Our ref: Project EnergyConnect (NSW - Eastern Section) (SSI-9172452)

Subject: Project EnergyConnect (NSW - Eastern Section)  
Request for Information

I refer to the Submissions Report and Amendment Report for Project EnergyConnect (NSW - Eastern Section) (SSI-9172452). The Department requests that you provide additional information on the matters below:

Figure 1-8 Photomontage of R501 – 6645 Holbrook Road, Gelston Park

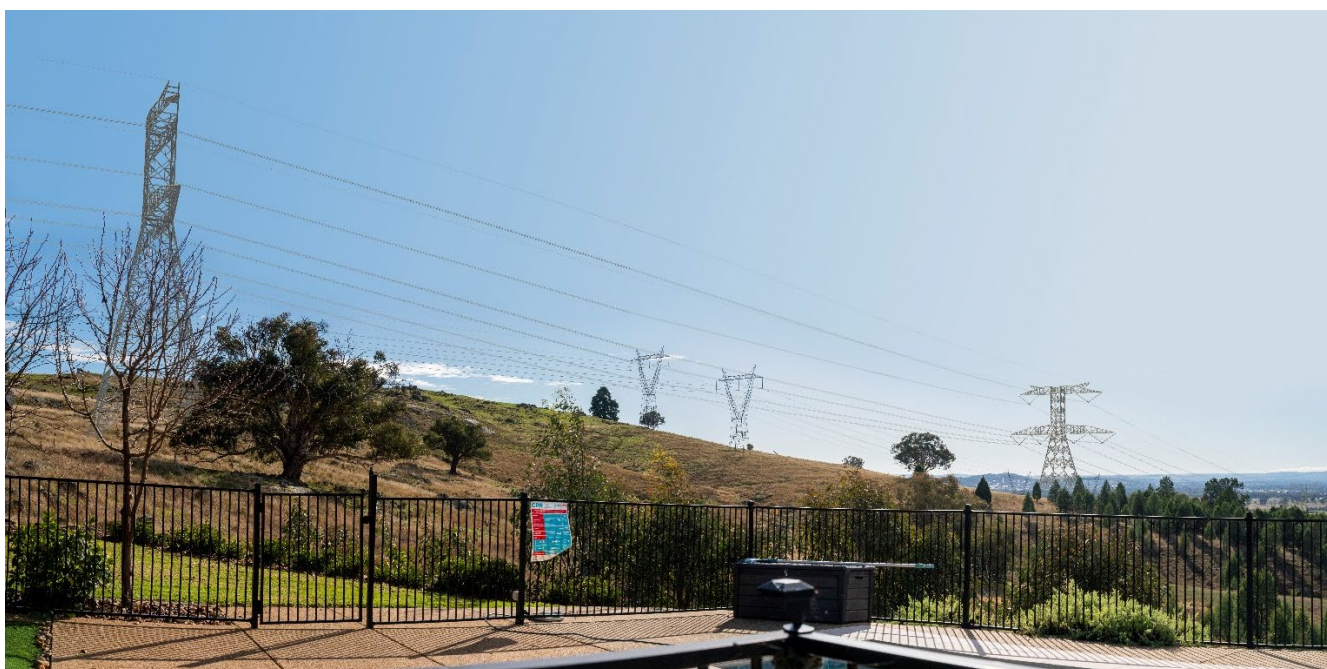
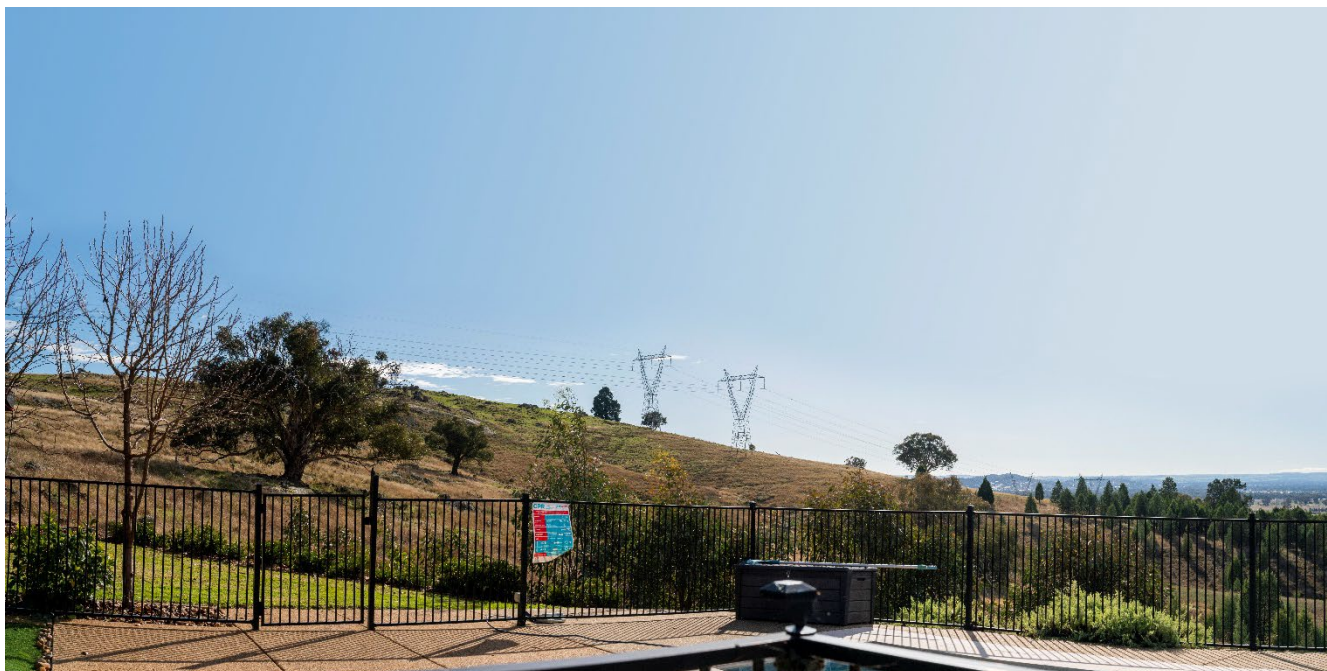
- Provide photomontages with and without proposed screening for receivers R186, R233, R385, R422, R432, R450, R461, R501, R26749 and R534.
- Table 2 of the *Revised landscape and visual impact assessment* includes receivers that were previously identified as residences and are now identified 'as not being a dwelling'. Update Table 2 as follows:
  - clarify the receiver type; and
  - assess any receiver that is considered to be a 'public viewpoint'.
- In addition, confirm that all public viewpoints located <500 m from the transmission line easement have been assessed.

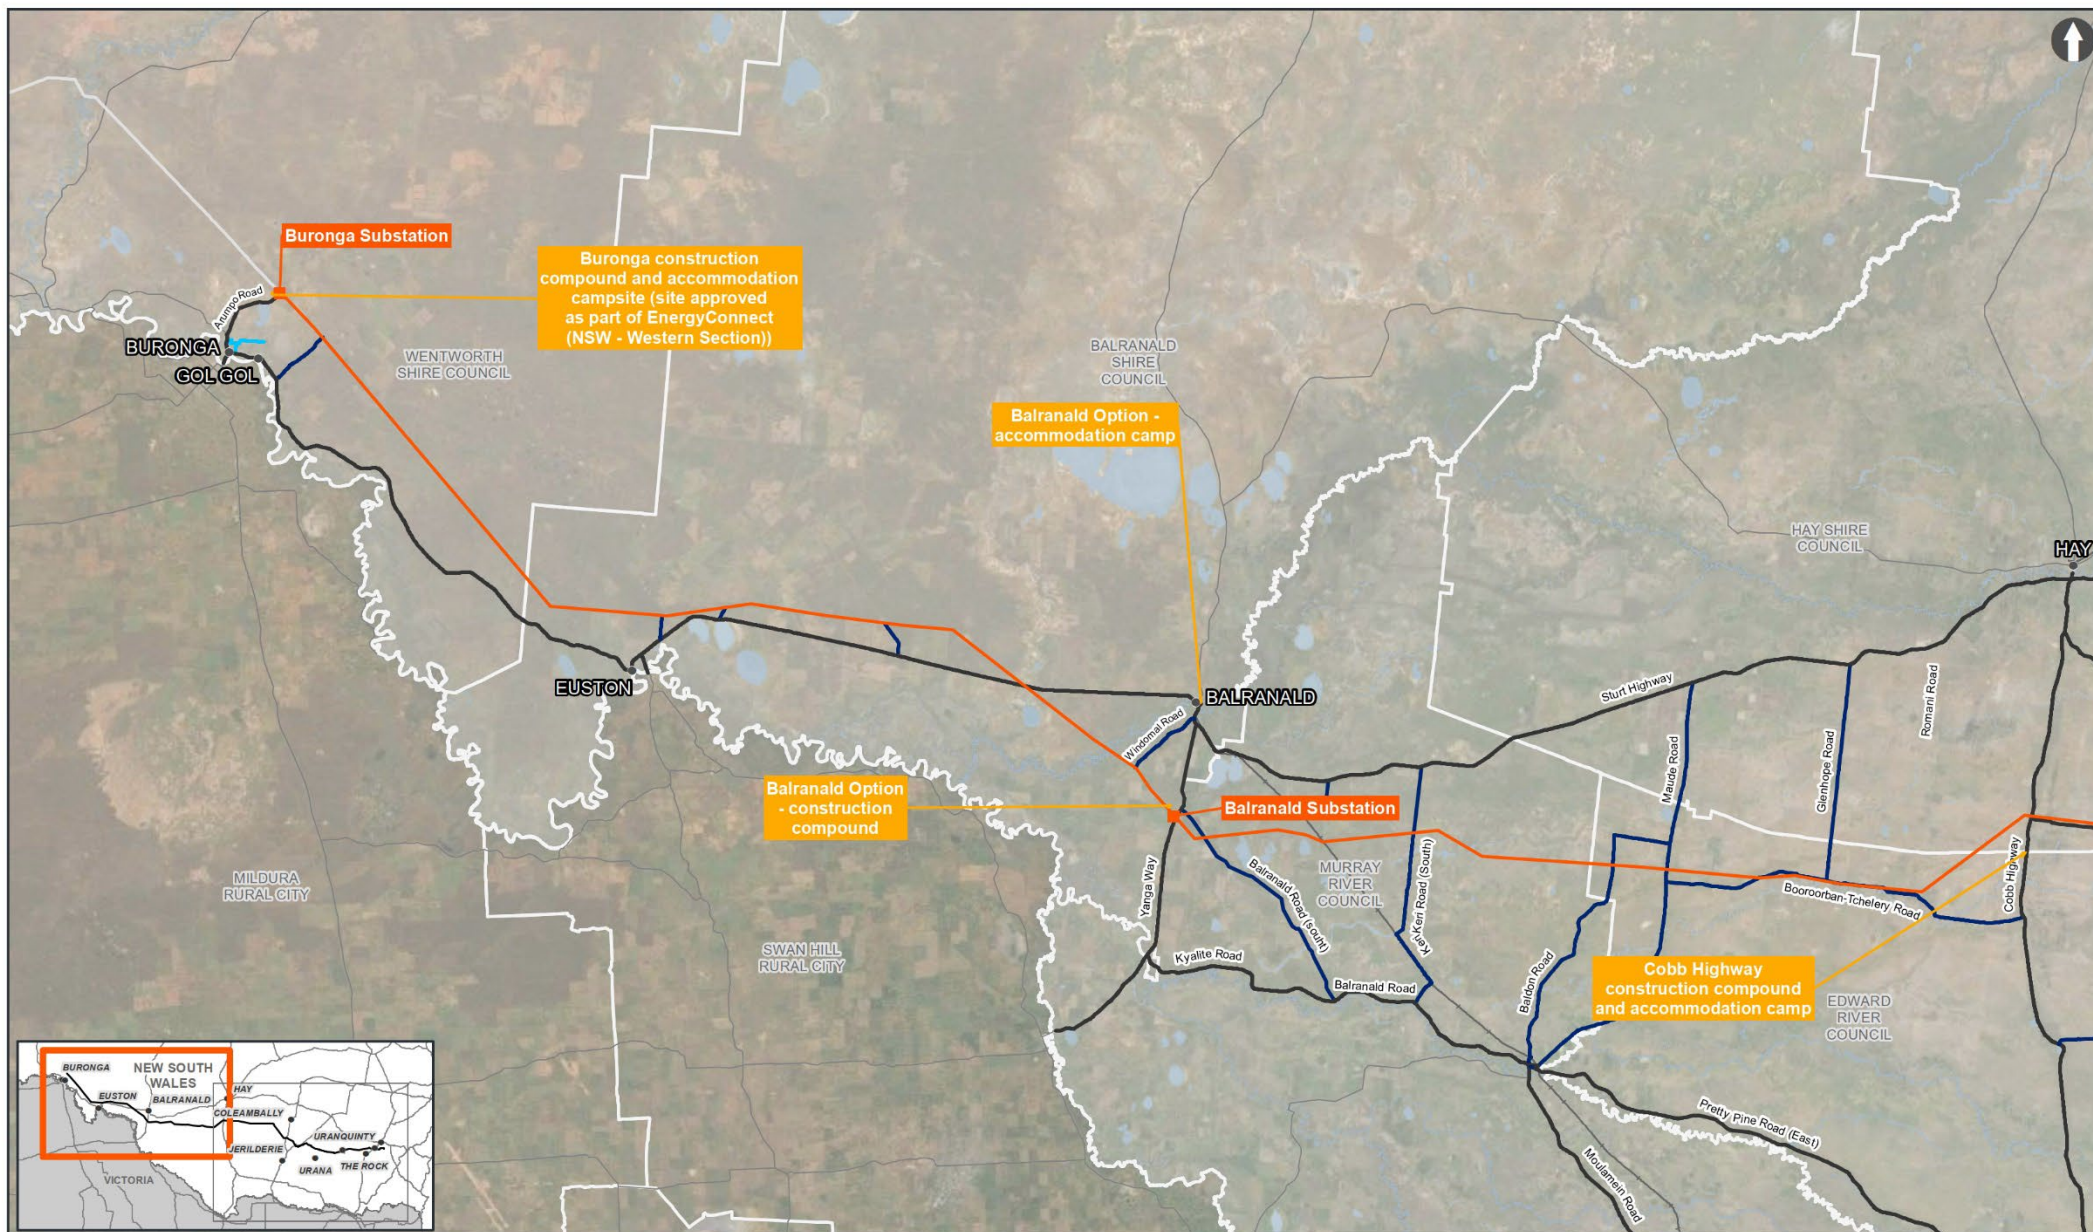
- Consolidate information detailing the proposed intersection upgrades and proposed Access Point (minor access tracks) upgrades.
